Subdivision Comments

From: Holly Erdman, Environmental Health Specialist II

Date: 11/14/23

RE: SP-23-0009 Sparks

BOWERS ROAD SHORT PLAT
 PART OF SECTION 26, T. 18 N., R. 18 E., W.M.
 KITTITAS COUNTY, WASHINGTON

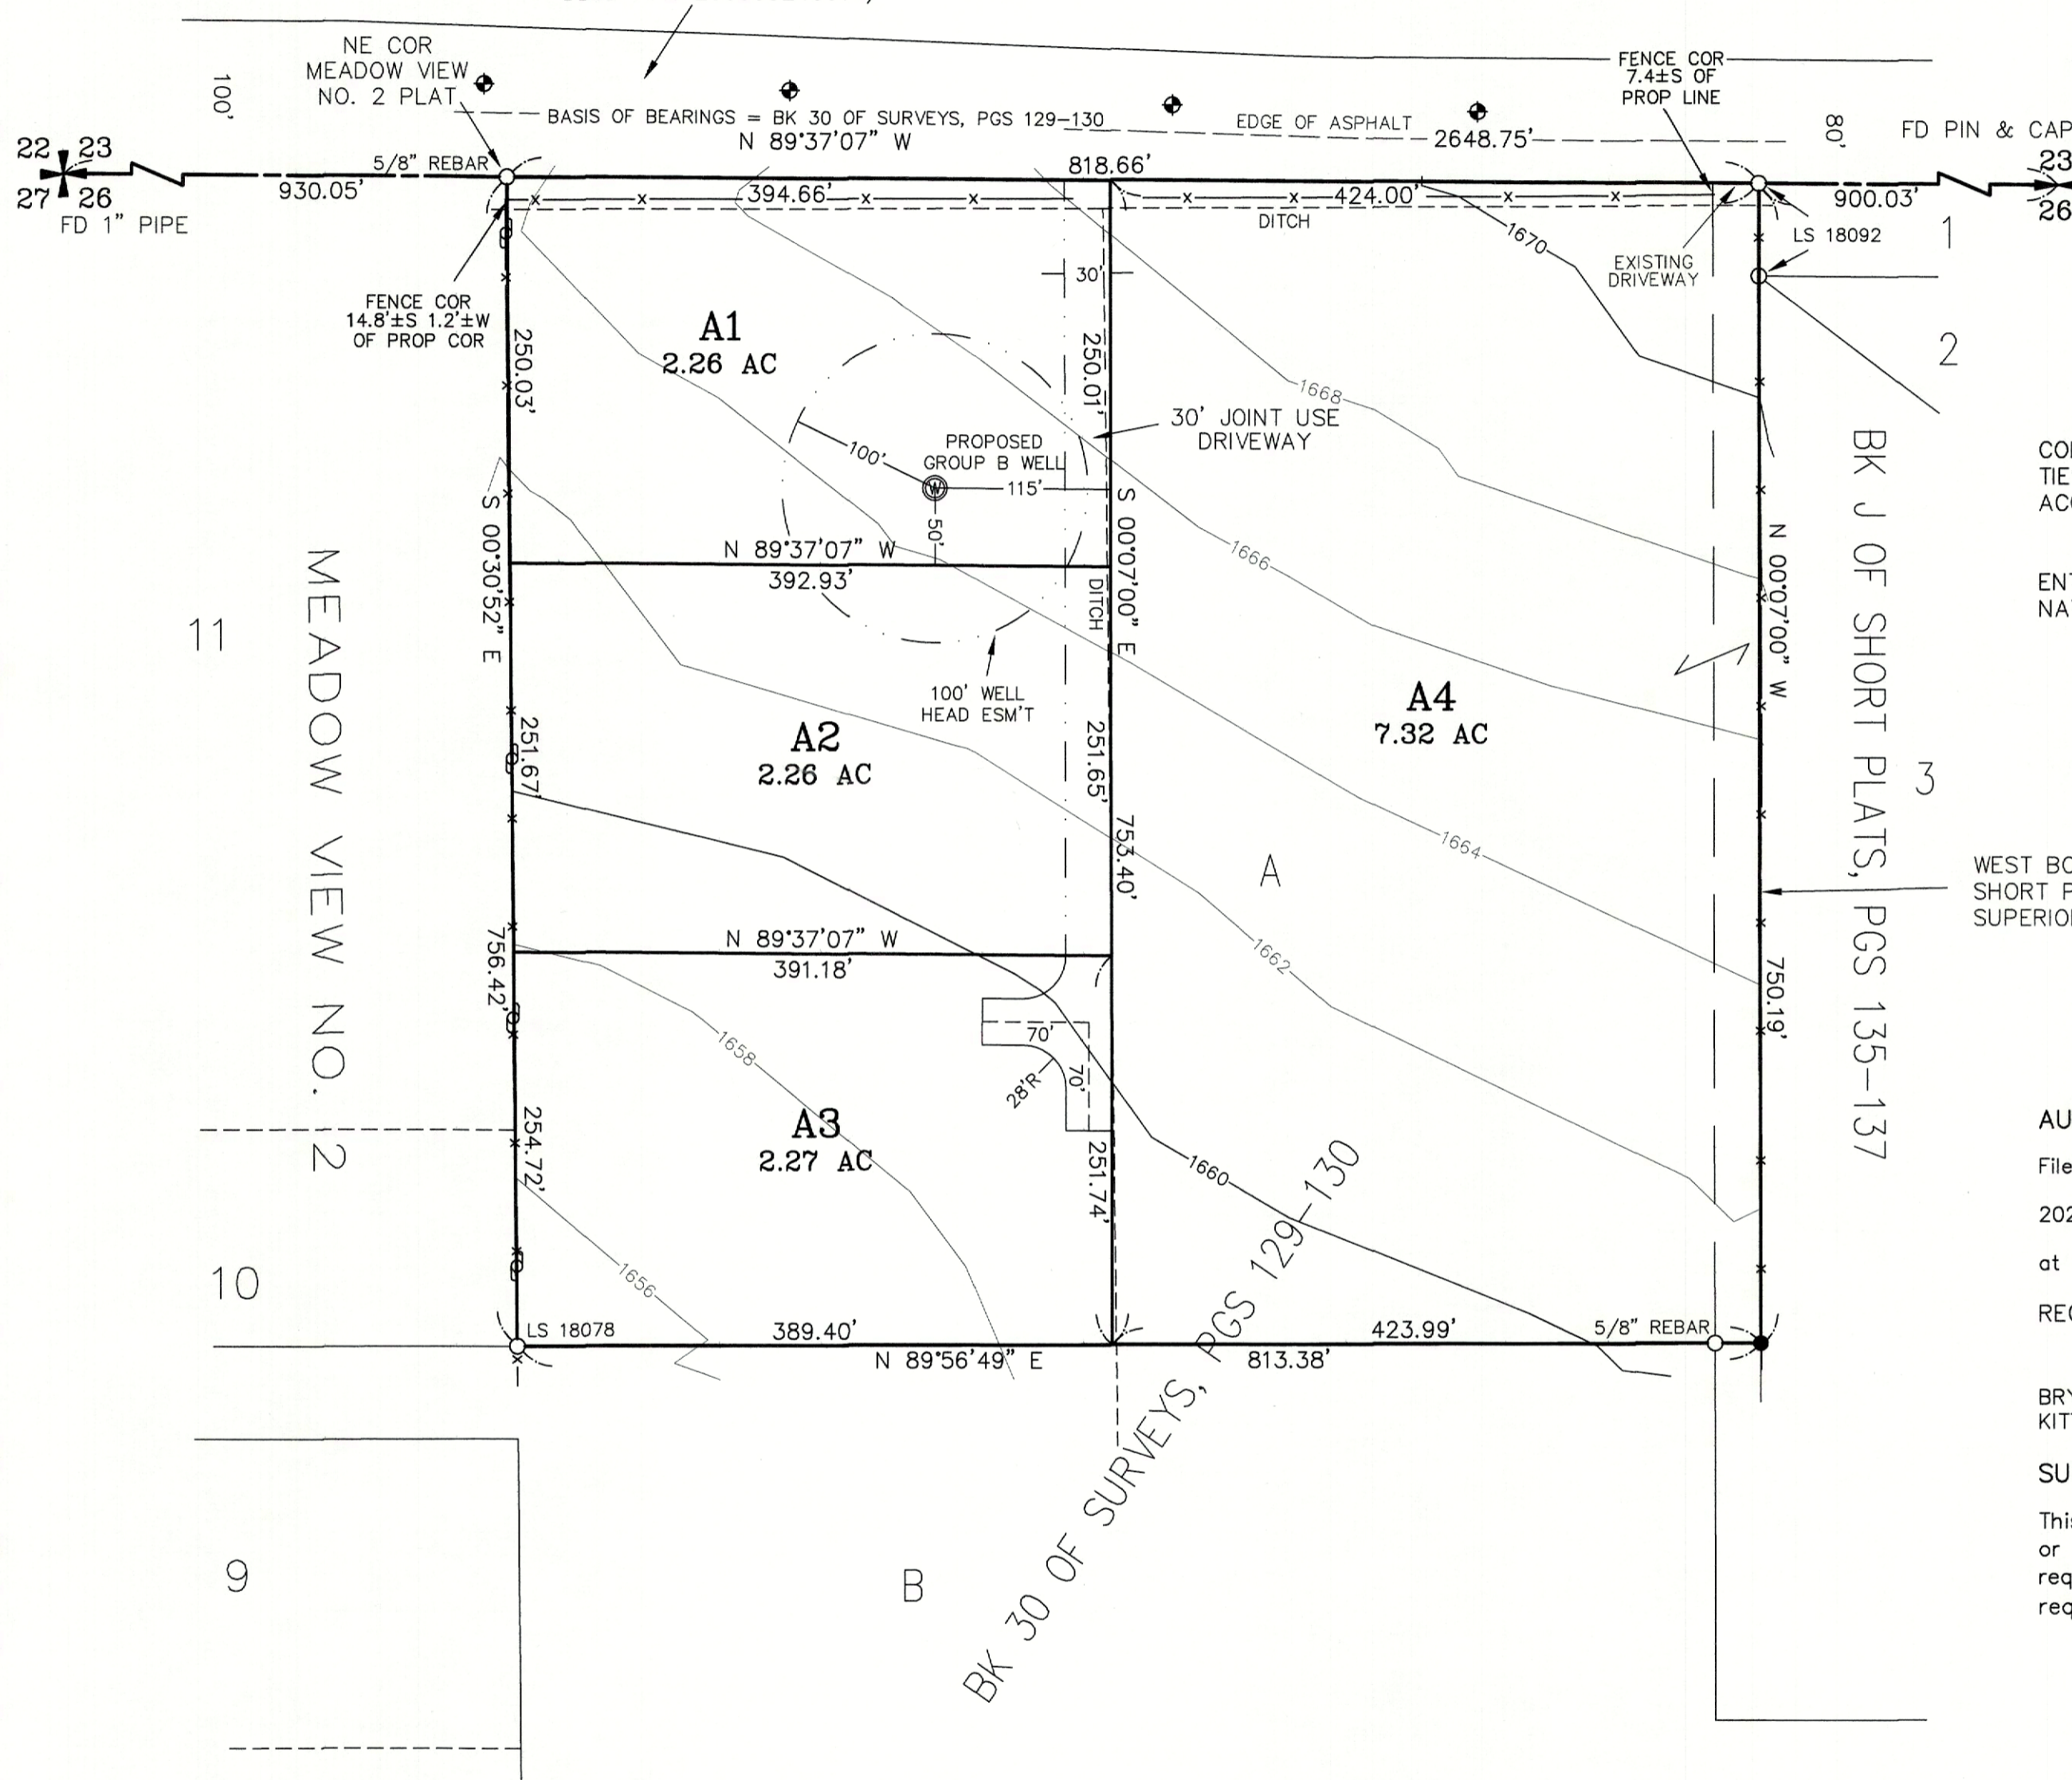
Any on-site septic systems that are to be utilized for wastewater management must adhere to the standards set by both the Washington Administrative Code, and Kittitas County Code. In accordance with KCC 13.04.090, a minimum of one soil log for each proposed lot where individual sewage disposal systems are contemplated must be completed.

The proposed short plat indicates the applicant will develop a Group B water system to serve the project. The location of the well site must be approved prior to drilling and a Group B water system must be approved by the Kittitas County Public Health Department. The applicant must prove legal and physical availability of water for all new uses of water on proposed lots.

A soil log must be done on each proposed lot.

A Group B public water system must be approved by the Kittitas County Public Health Department with a public water system ID# issued by the Washington State Department of Health, Division of Drinking Water.
